From: [REDACTED]
Sent: 04 July 2024 11:03
To: Planning
Subject: Objections and comments to planning application 3/2024/0422

Objections and comments to planning application
3/2024/0422
12 Northcote Park Langho BB6 8FB

Figure 3: Existing and proposed elevations.

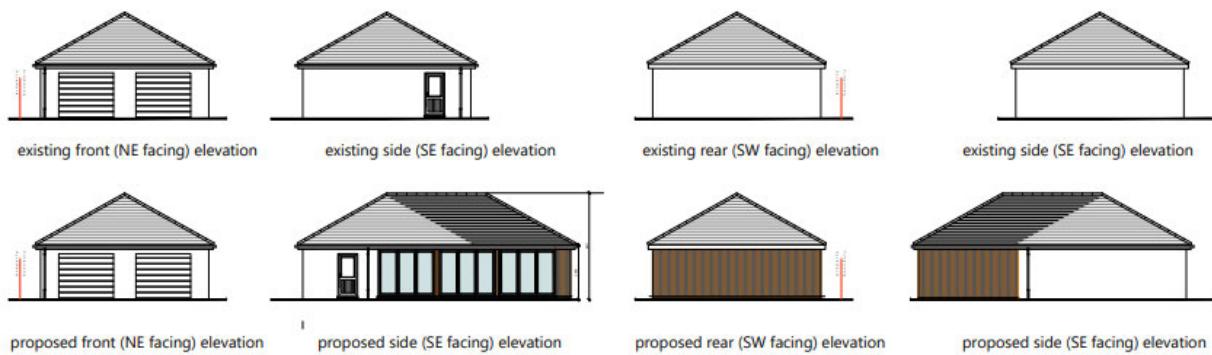
How could concrete roof tiles be even considered on a brand new development that is roofed entirely in Italian Slate?

Cedar timber cladding! The entire estates detached garages are white rendered with natural stone so anything other than this would be totally out of character. Both the material and the shape of the cladding would be totally different and outstanding.

Other parts of the specification mention strapping to Velux roof lights! What is this all about?

7. Landscaping image shown on plan: It features the Cedar wood cladding, this image depicts some steps and high level balcony with glass balustrades behind the planned garage extensions. Absolutely unacceptable should this structure be being considered. It would have the effect of [REDACTED]

[REDACTED]. The image also despite not being to scale shows a very shallow pitch to garage roof whereas in reality they are quite steeply raked and high pointed at the top.
